Recommendation Report for Planning Permission

REF NO: AW/246/19/PL

LOCATION: Land Adjacent
to 34 Wakefield Way
Aldwick
PO21 3RS

PROPOSAL: Erection of 1 No. 2 storey end of terrace house.

PROJECT	Wakefield Way	DATE	19/08/19
TITLE	Site Plans	DRG NO	IBA/520/01
SCALE	As Noted	REVISIONS

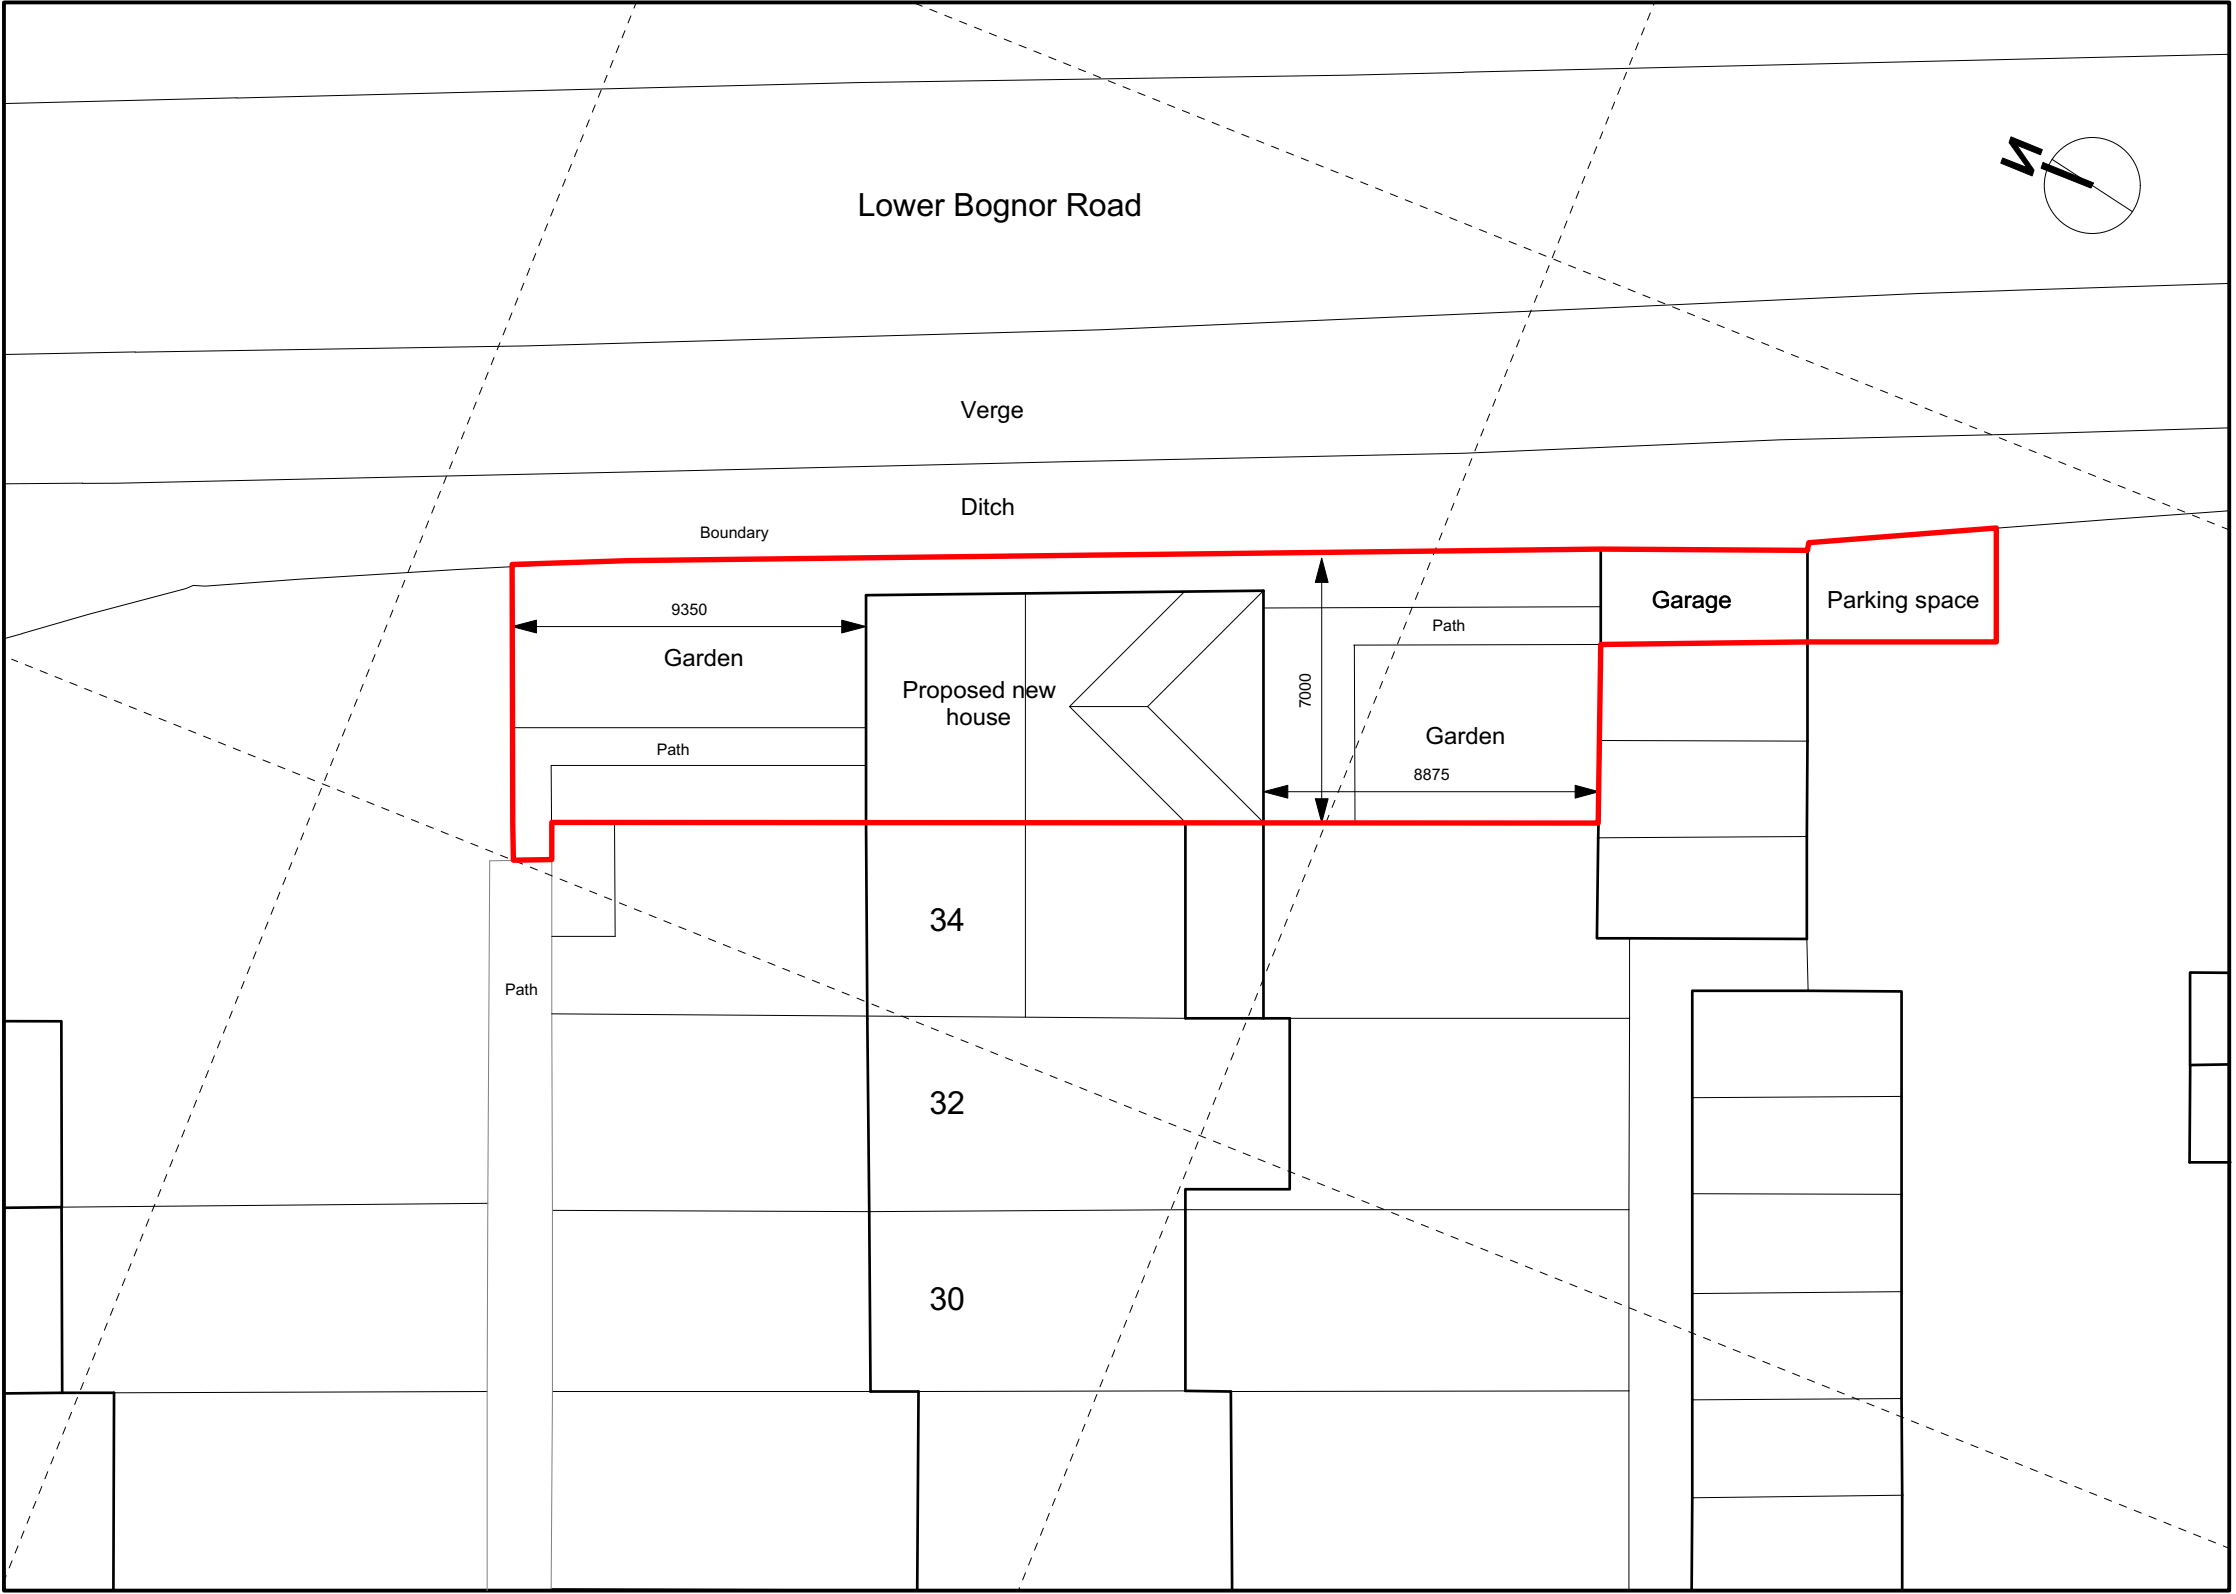
- Considers that the T05 Oak tree should have been classified as category B not C and that its long term retention is highly desirable as it could be viable for in excess of 100years. It, along with other nearby trees, are major landscape components defining the verdant character of the area and having amenity value in the local landscape;

- The root protection area shown for the Oak does not reflect the likely area which contains sufficient roots and rooting volume to maintain the tree's viability;

- On this basis, the proposed tree protection measures propose extensive intrusion into the root protection area;
- The proposed change in intensity of land-use around the new dwelling will eventually lead to damaging compaction over the rooting area of T05 and due to the canopy overhang dominating the rear garden, there will inevitably be a 'future residential pressure to prune' further spoiling the visual amenity currently provided by this tree;

- Cellular soakaways will be required to provide drainage and it is not clear where these will be sited; and
- The likely extent of RPA intrusion is problematic and the associated high risk of short and long-term damage to T05 is unlikely to be adequately mitigated by engineering solutions at this site.

The Tree Officer has extensively assessed the application proposals and has severe concerns regarding the impact of the dwelling on the TPO Oak tree. It is not considered that the RPA has been drawn correctly and therefore, the impact is likely to be greater. The tree protection measures will result in extensive intrusion into the RPA. The change in the intensity of the land-use around the new dwelling will lead to damaging compaction over the rooting area of the tree and also result in future pressure to prune (due to tree overhang/shading/tree litter). The Tree Officer is concerned as to where drainage soakaways will be sited.

In terms of parking, the Highways Authority advise that the existing garage, whilst undersized can still be counted as 1 parking space but that the space to the front of the garage would be restricted if someone parked in front of the opposite garage. They consider the parking arrangements may result in amenity impacts to other residents but are not considered to represent a safety concern.

The parking proposal is for the existing dwelling to lose its undersized garage/adjacent restricted space and for the new dwelling to have these instead. The existing dwelling would have no spaces whilst the new dwelling would have two imperfect spaces. The Local Authority indicated to the applicant (22/10/19) that the parking provision could be supported. However, it is material that the Council has adopted a Parking Standards Supplementary Planning Document (15/01/20).

This SPD sets out a requirement for 2 spaces for each dwelling and states that garages be considered as half a space if they are at least 3m by 6m (measured internally). The parking requirement for the 2 dwellings would be 4 spaces whilst the provision would only be 1 space (and this space is restricted).

The under provision of parking spaces for the dwelling might have been acceptable on the grounds of sustainability and that together, the two imperfect spaces could be accepted a single space. However, the complete loss of spaces for the existing dwelling cannot be supported and the proposal conflicts with the Arun Parking Standards SPD and with policy T SP1 as it relates to parking provision.

IVON BLUMER ARCHITECTS LTD			
PROJECT	Wakefield Way	DATE	19/08/19
TITLE	Proposed Floor Plans	DRG NO	IBA/520/02
SCALE	1 : 50	REVISIONS

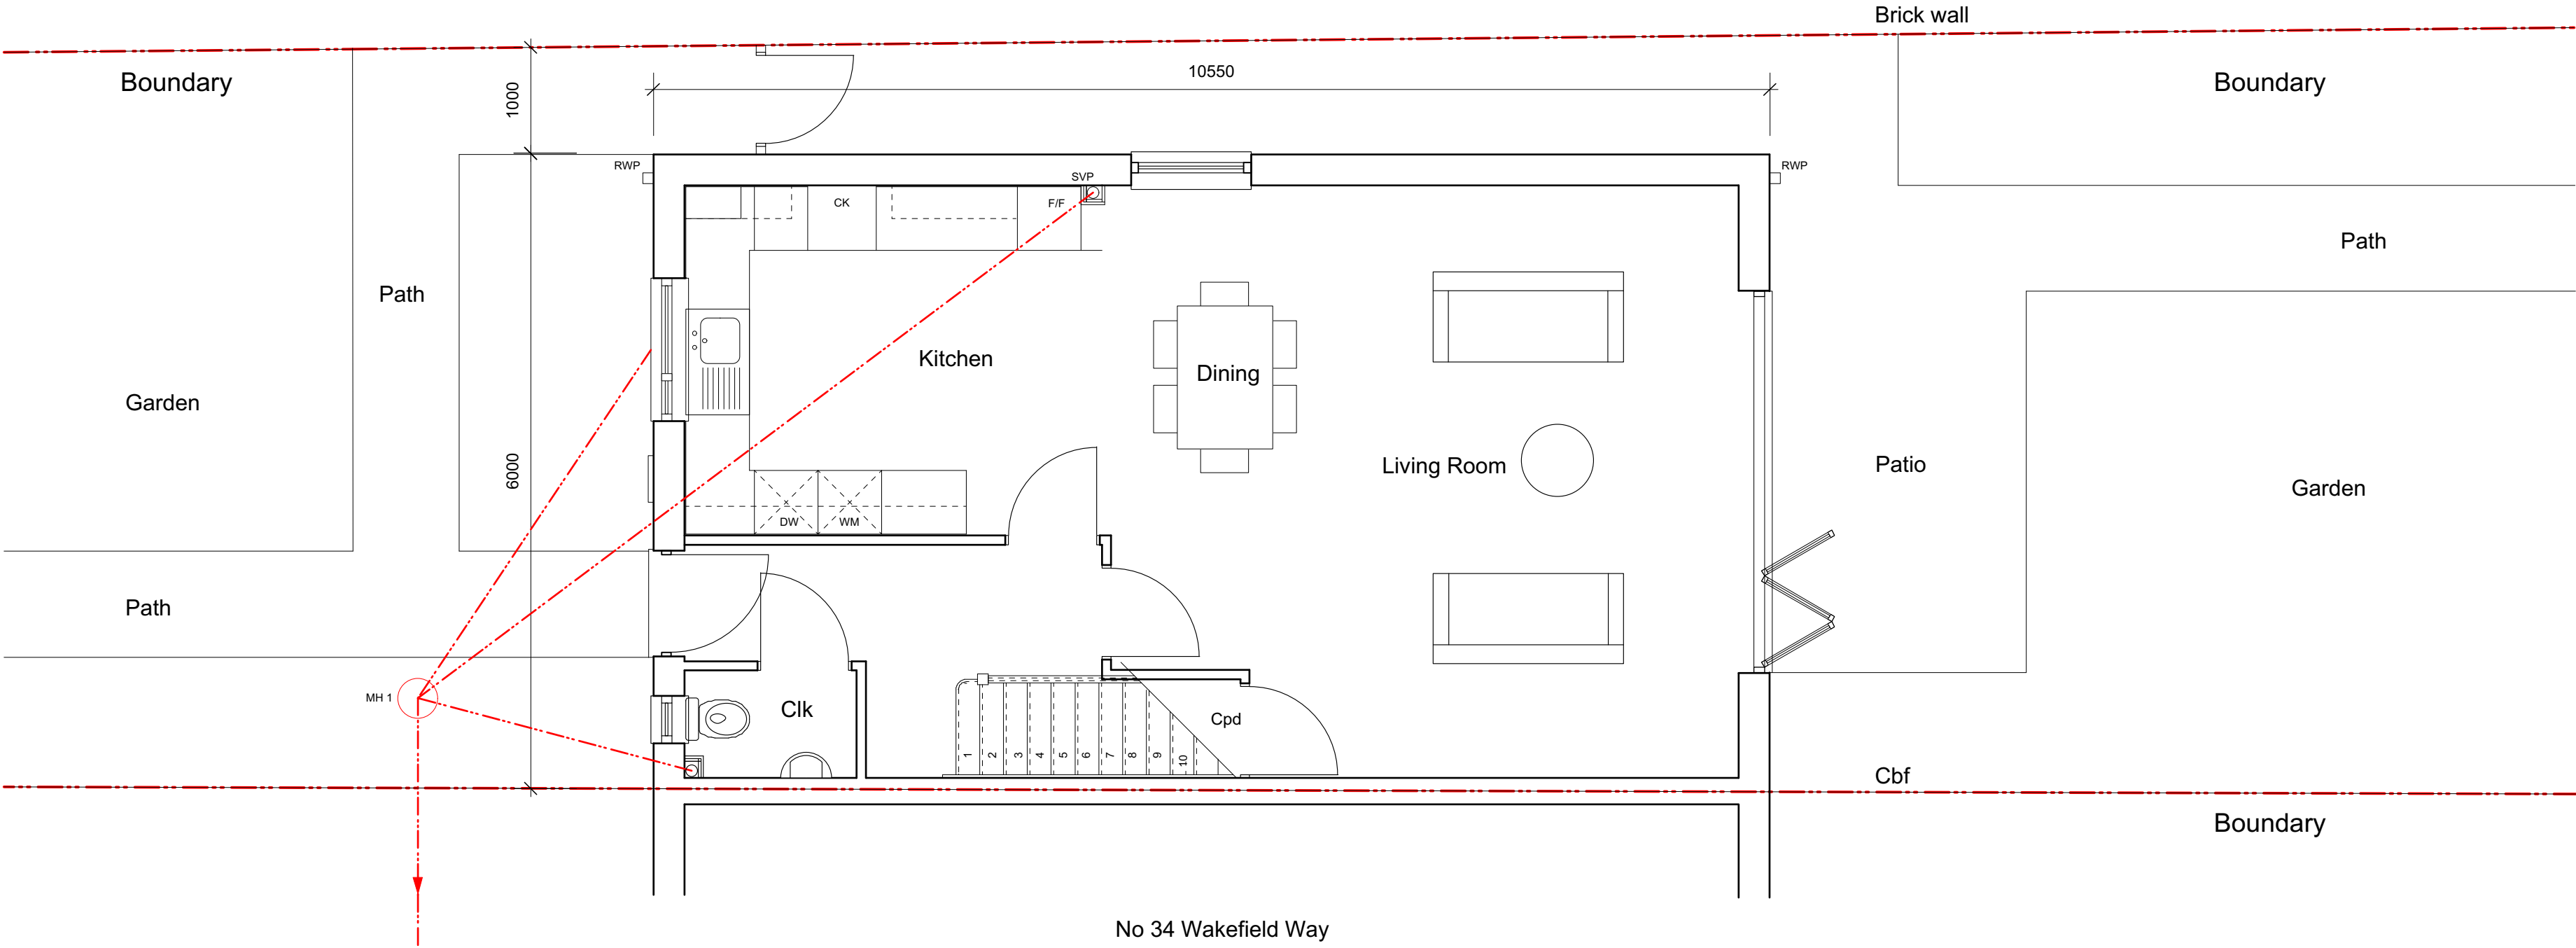
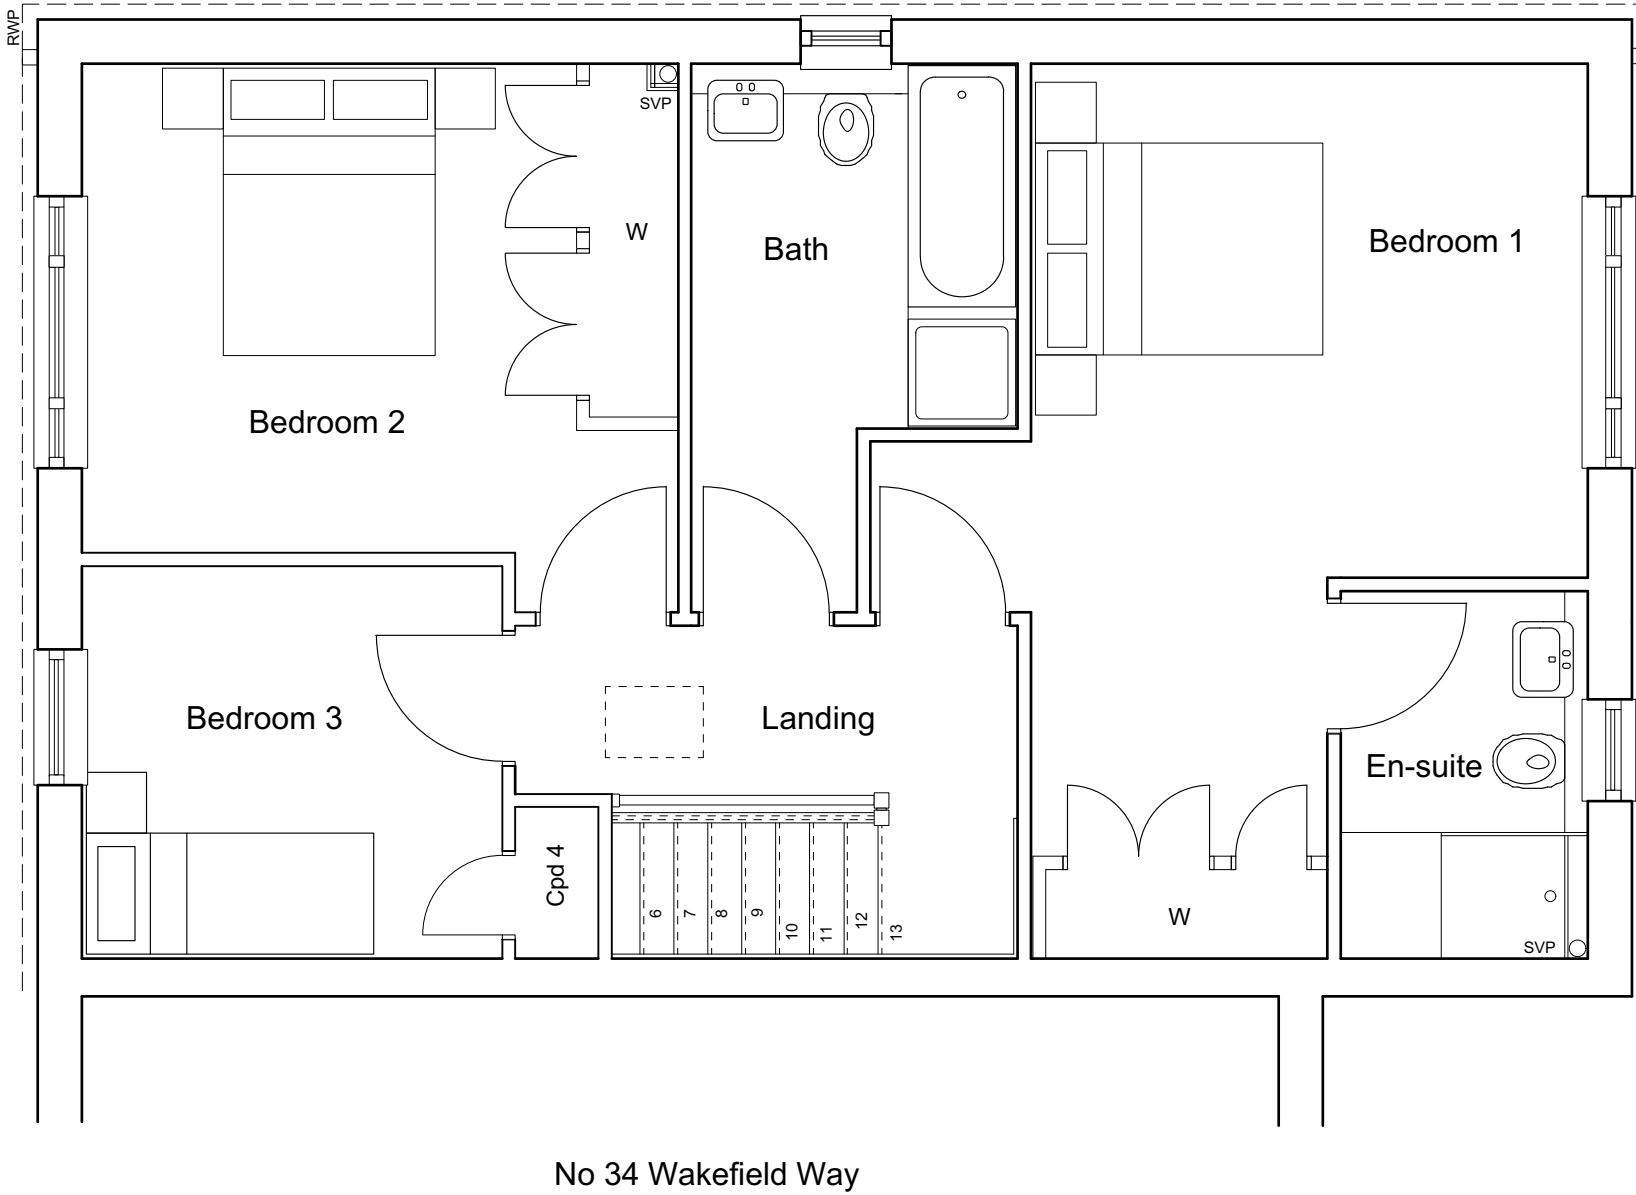
ALP policy D DM2 states: "The planning authority will require internal spaces to be of an appropriate size to meet the requirements of all occupants and their changing needs. Nationally Described Space Standards will provide guidance". It is therefore necessary to assess the proposal against internal space standards set out in the Governments Technical Housing Standards (Nationally Described Space Standard) to determine if the buildings will be suitable for residential use. The requirement for a two storey, 3 bedroom, 5 person dwelling is 93m² and the dwelling exceeds this standard (at 110.9m²).
